**From:** Sue Howell  
**Sent:** 19 December 2018 16:37  
**To:** Planning.Responses  
**Cc:** Michael Eastham  
**Subject:** RE: Planning Consultation on WA/99/18/DOC

Comment from Greenspace

**Site Address:** Land East of Tye Lane Walberton Arun

**Description of Works:** Application for approval of details reserved by conditions imposed on planning reference WA/44/17/OUT relating to conditions 5, 9, 10, 11, 12 13, 16, 17, 24, 25, 27, 28, 30, 32, 33, 36,

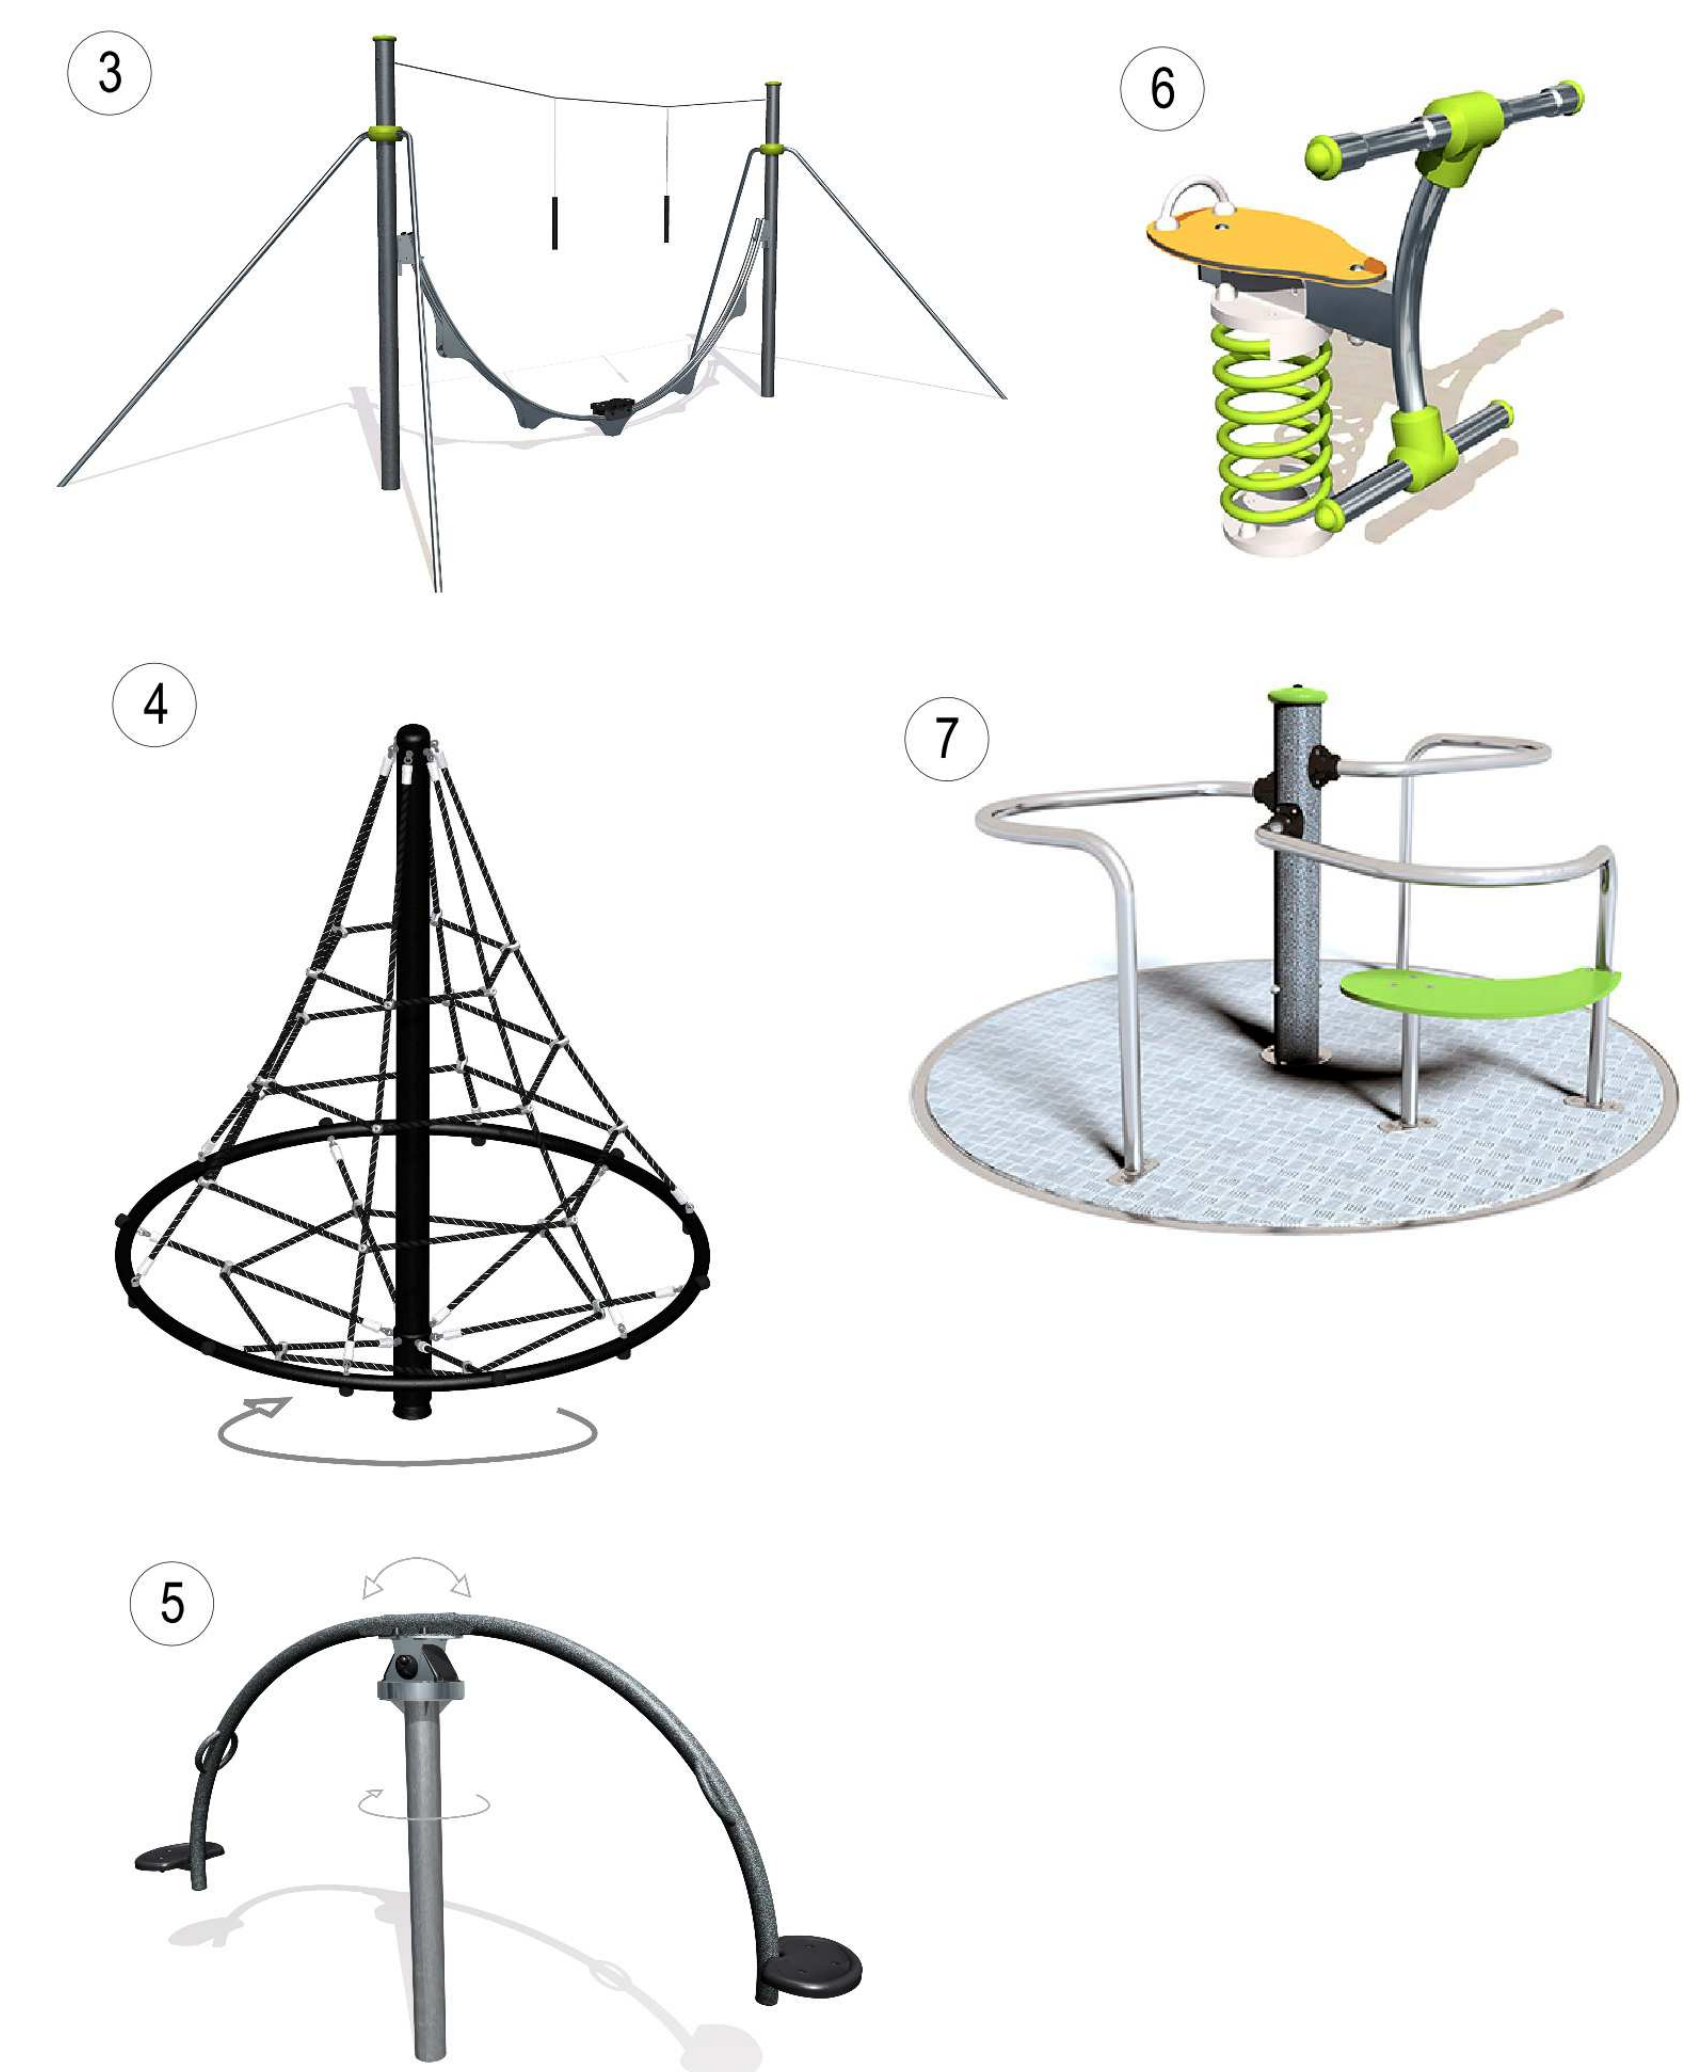
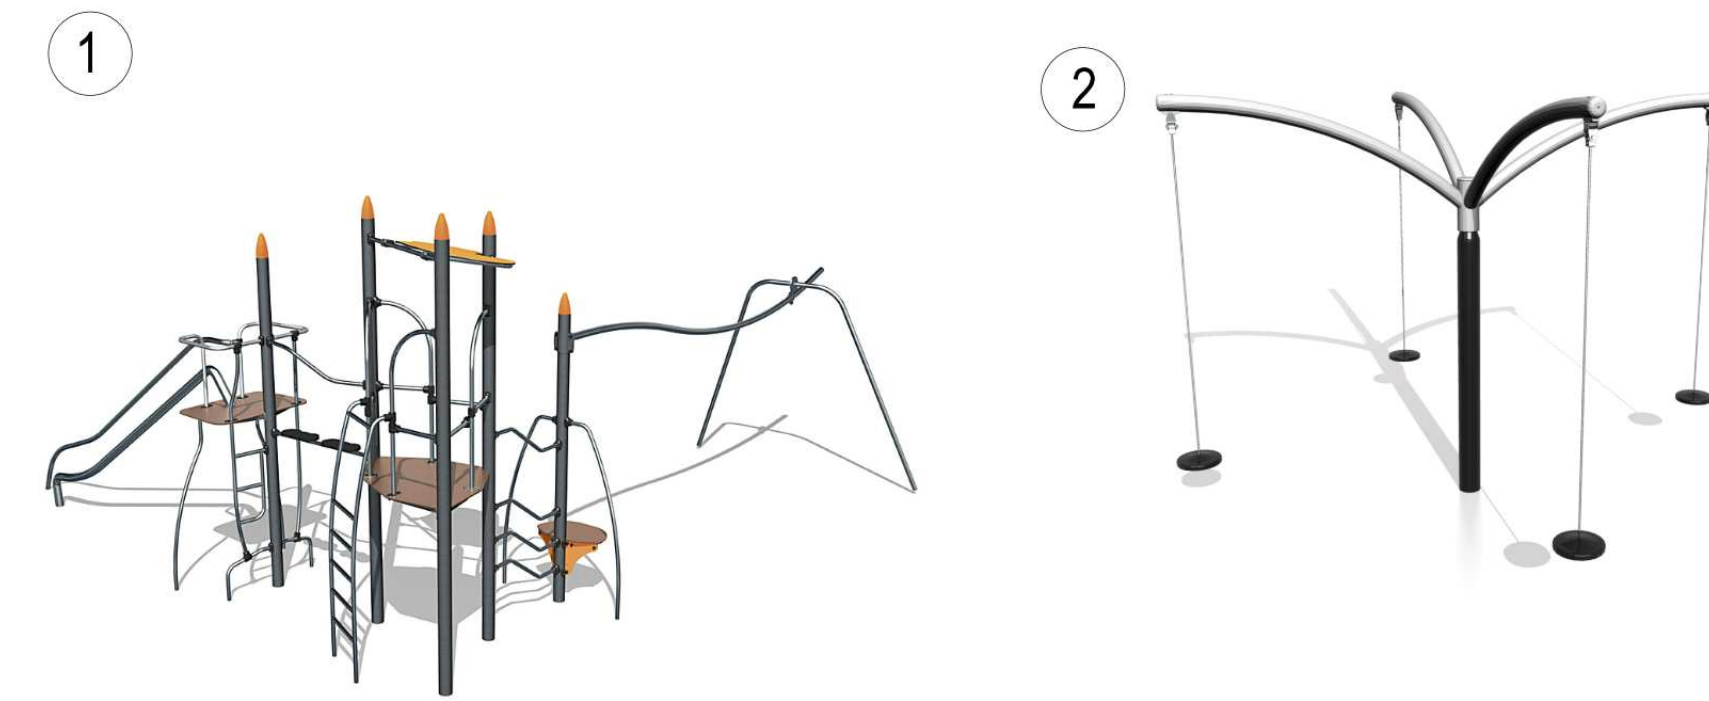
As noted in comments below Paly area 1 detail has a footpath pathway which runs through the play area which would mean that all footfall would be through this area. This would not be desirable as it would mean that all pedestrians and potentially dog walkers would have to traverse through the play area to continue using this pathway. A pathway to the periphery in addition to internal paly area pathways would be required. Play area 2 is shown next to indicated Tennis Courts – this provision needs to be concluded as to whether tennis or MUGA is appropriate for this development.

The LAP provision still need to be detailed in location and formation.

The LEAP as shown in Landscape Masterplan CSA/3823/111 October 2018 does appear to be tucked in the far corner of the site and is now shown to have a pathway running through the centre which whilst connectivity to pathways for accessibility is required, a main pathway route through a play area would not be supported. Locating the play area more centrally within the development should also be considered.

Recommendation for the provision Multi-Use Games Area (MUGA) was made at PAA stage and again at approved outline stage, where the preference and support documentation was made for MUGA rather than tennis court provision. MUGA are fast drying all year round play surfaces with a low maintenance cost which appeal to a wide demographic due to the range of activities they facilitate and accessibility they offer. Representation was made by Walberton Parish Council who also supported MUGA provision for this development.
